Your Reference: SSD 5263  
Our Reference: SYD12/01085  
Contact: Dianne Rees  
Telephone: 8849 2237

**Transport**  
Roads & Maritime  
Services

**PROPOSED STAGE 1 EXPANSION TO BLACKTOWN HOSPITAL  
INCLUDING A NEW CLINICAL SERVICES BUILDING, ALTERATIONS TO  
EXISTING MAIN HOSPITAL BUILDINGS, INTERNAL STREET, SITE  
LANDSCAPING, NEW PERMANENT ACCESS ON BLACKTOWN ROAD,  
ADDITIONAL PARKING AND ASSOCIATED BUILDING SERVICES  
AT 18 BLACKTOWN ROAD, BLACKTOWN**

DRAWING TITLE
BIN-BLACKTOWN INFRASTRUCTURE
BLACKTOWN ROAD INTERSECTION
STORMWATER LAYOUT PLAN
SCALE (B1) 1:1000
PROJECT NO. NB11472
DRAWING NO. BIN-CV-DG-SK24
REVISION
B

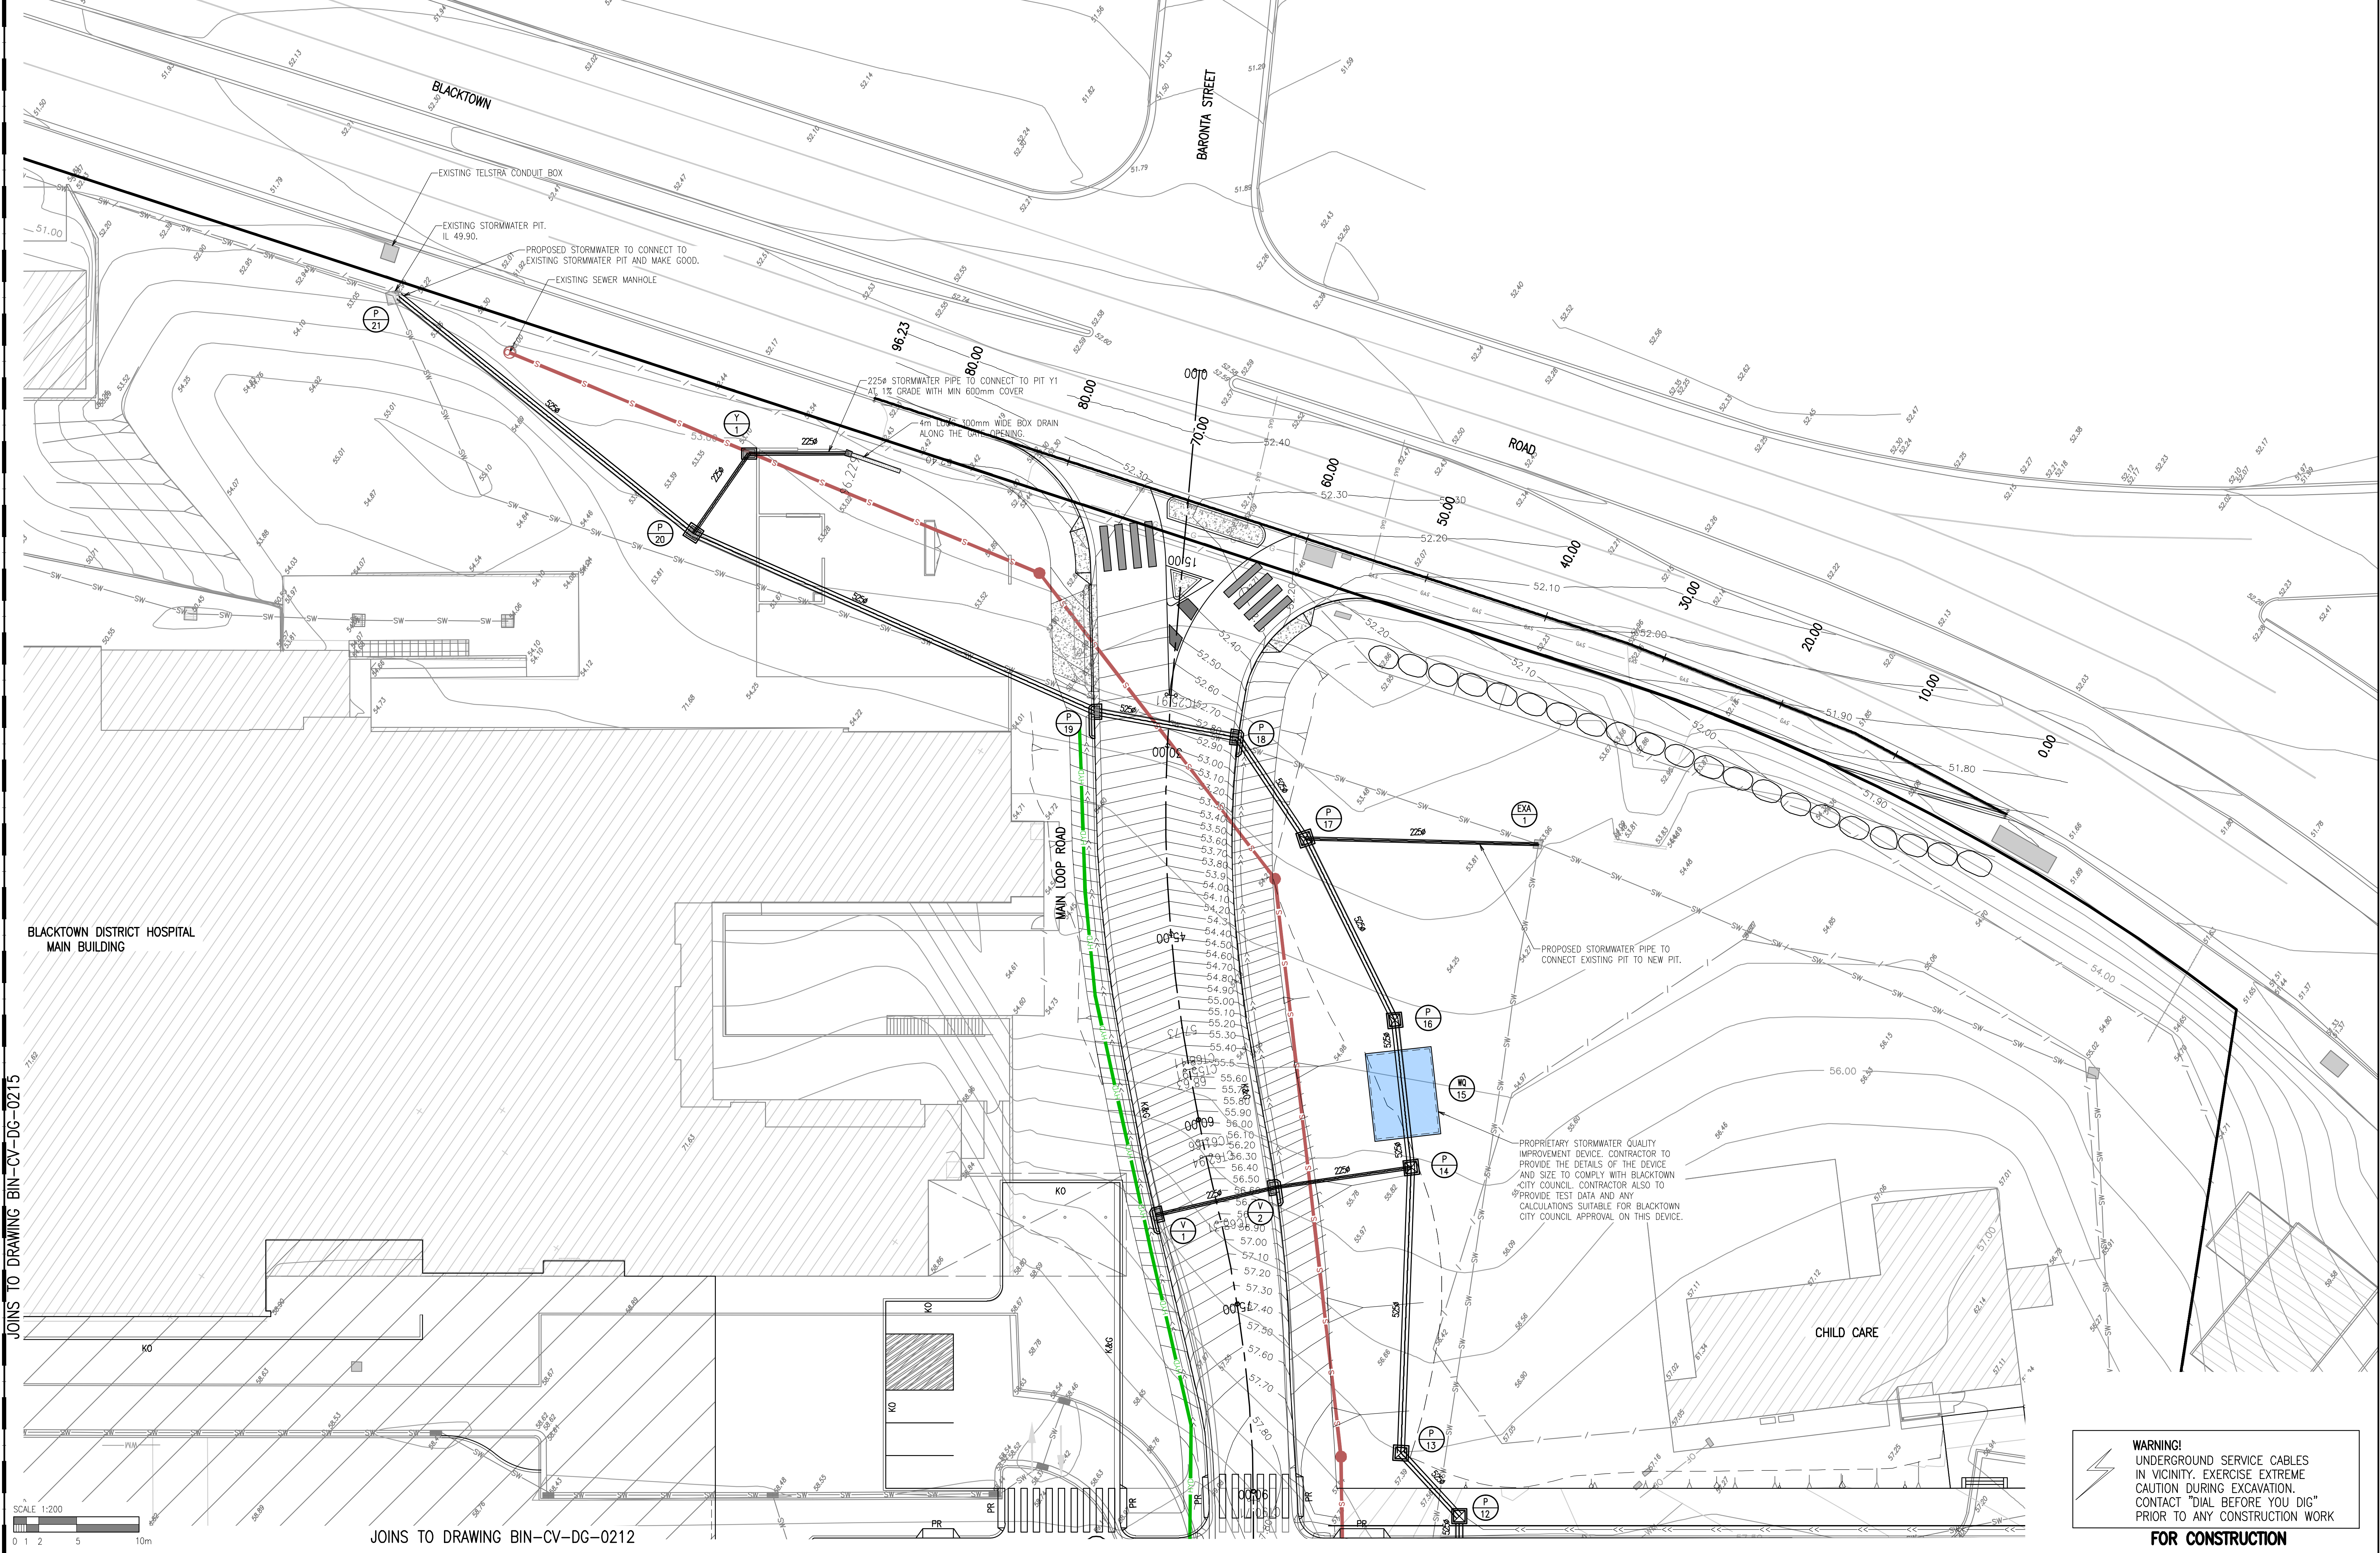
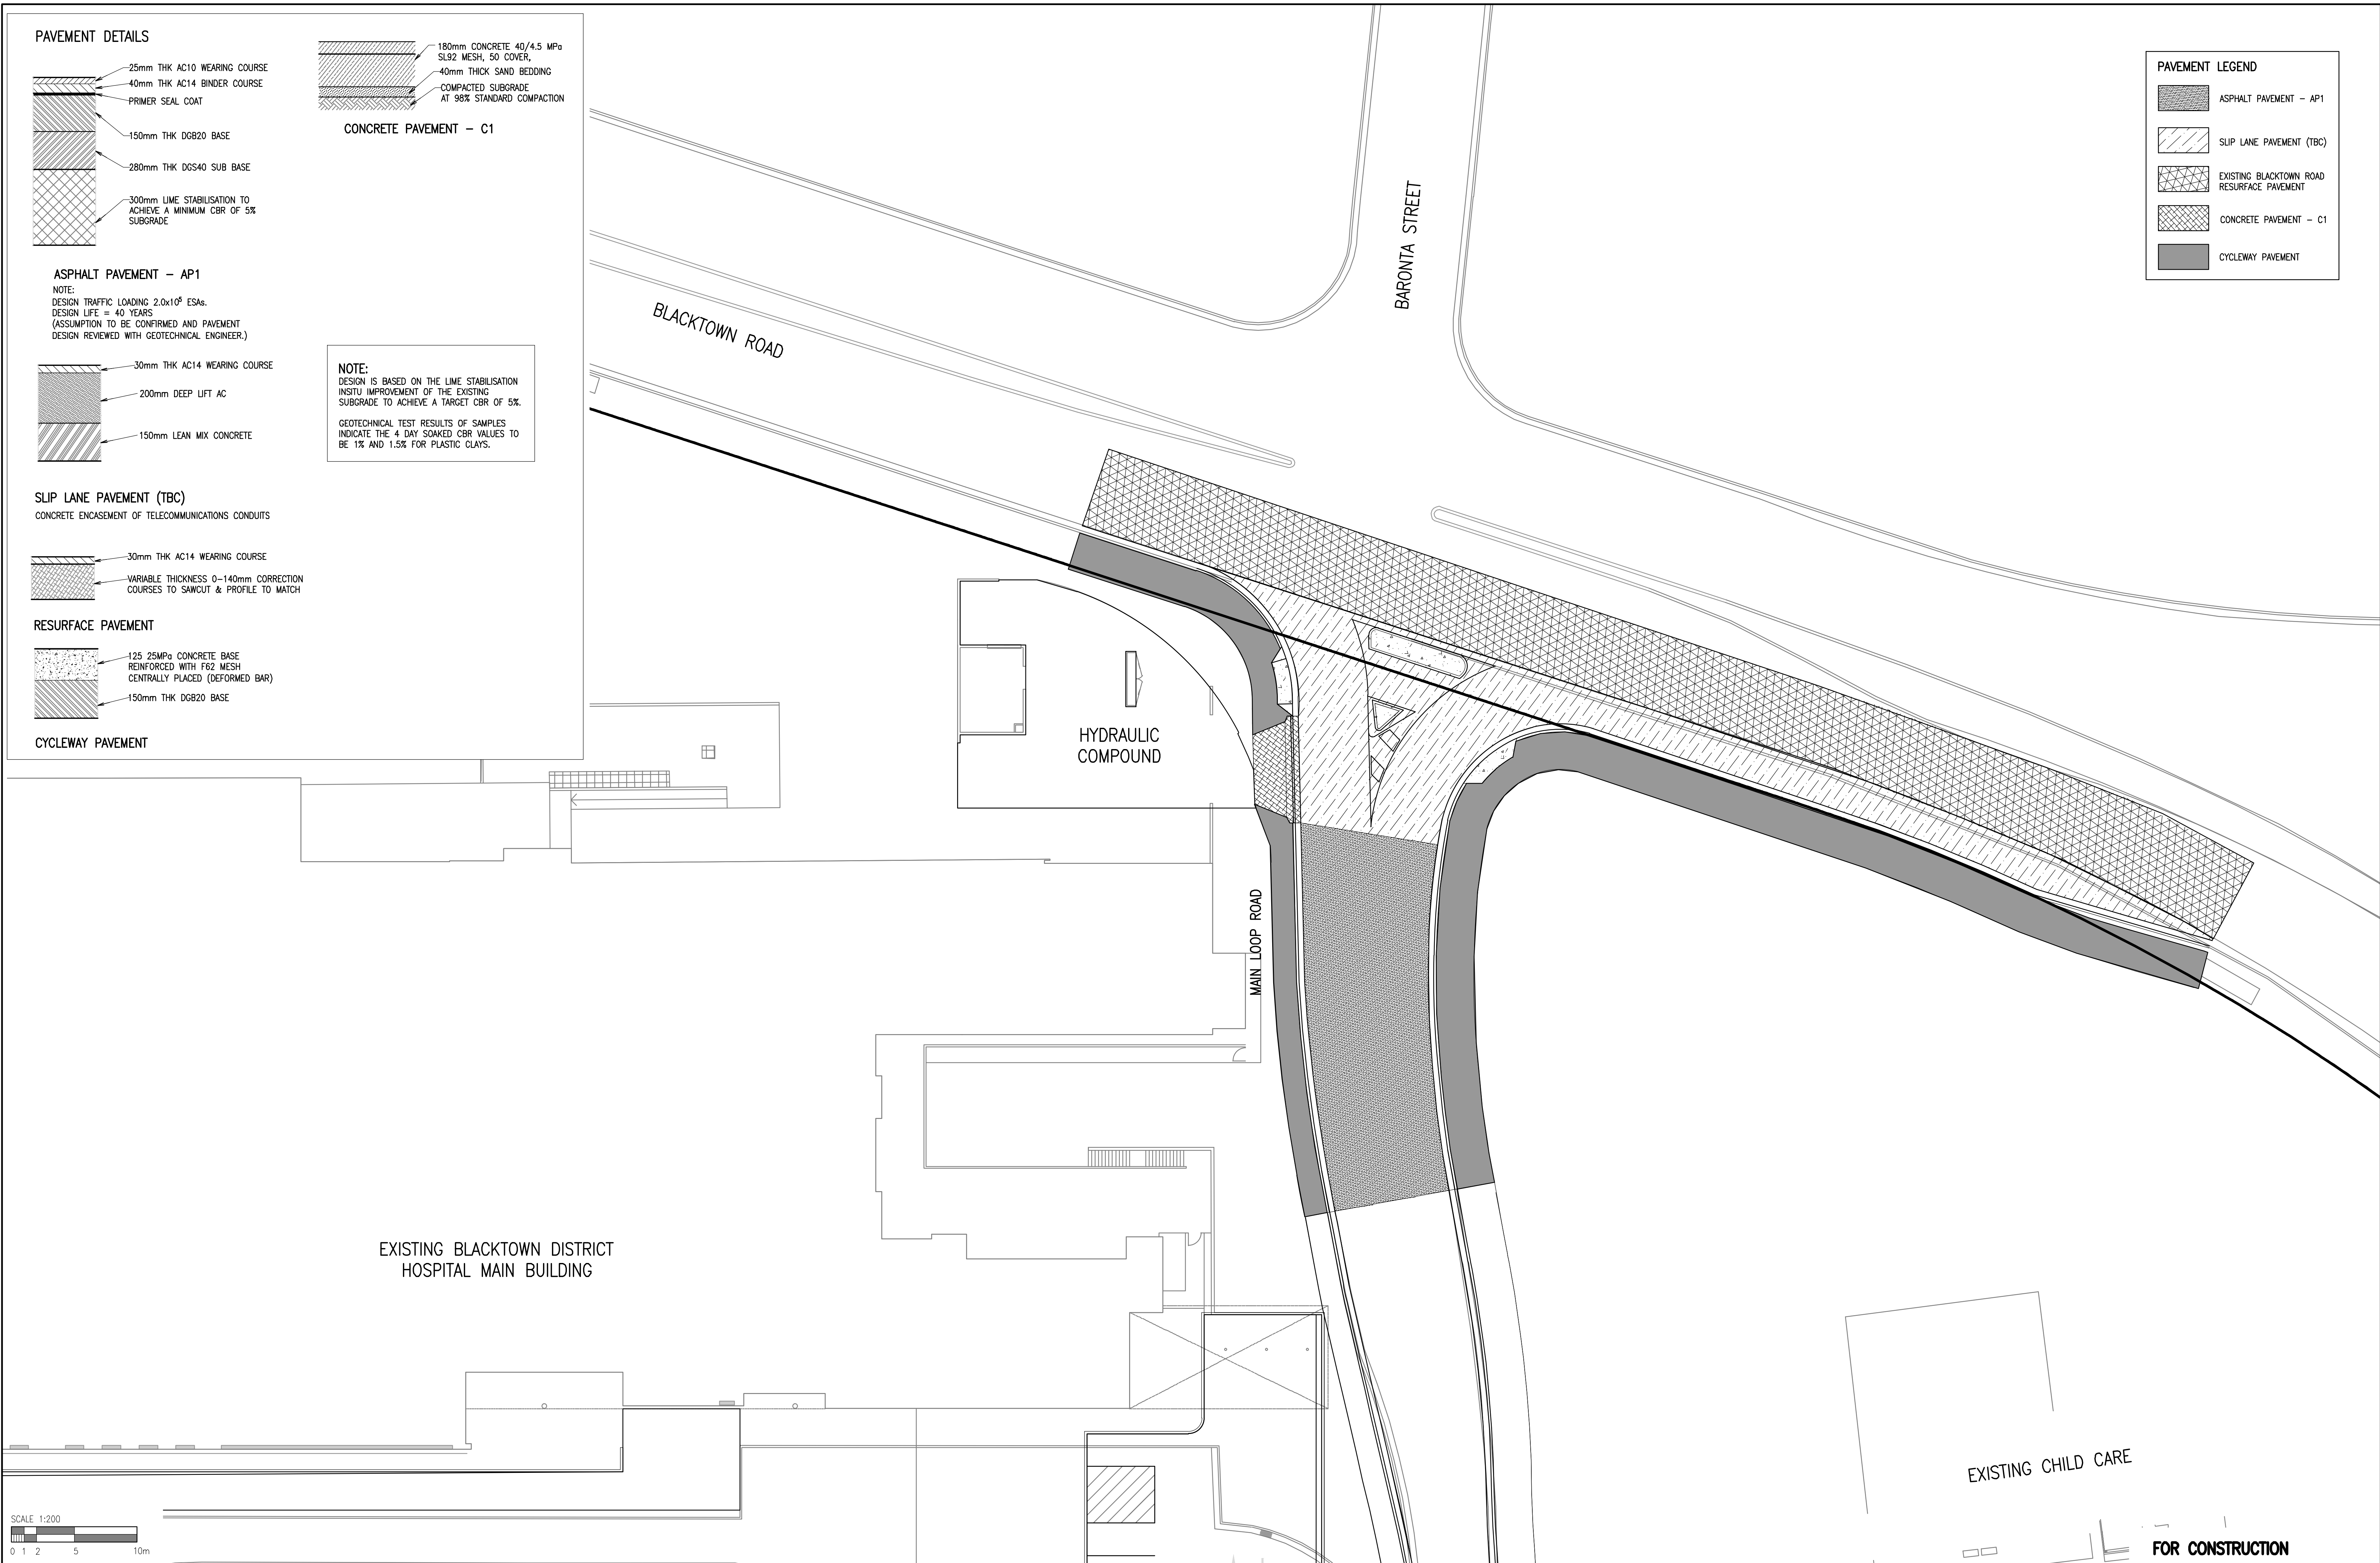
The location for the permanent access and Gateway to the hospital precinct is to be opposite Baronta Avenue via a two-way, left in/left out access only. An amended design for the permanent access has been submitted to RMS for review in the period since the lodgement of this application to the Department. RMS raises no objection to the location of the permanent access opposite Baronta Avenue subject to it being maintained as a left in/left out access only. RMS does not support the signalisation of this access to the hospital precinct due to the close proximity of the signalised intersection of Wall Park Avenue and Blacktown Road, and on sight distance and network efficiency grounds.

15. The shared path in the vicinity of the left in/left out access on Blacktown Road is to be reinstated as a reinforced concrete shared path to match existing and to RMS requirements.

16. Detailed design plans and hydraulic calculations of any changes to the stormwater drainage system are to be submitted to RMS for approval, prior to the commencement of any works.
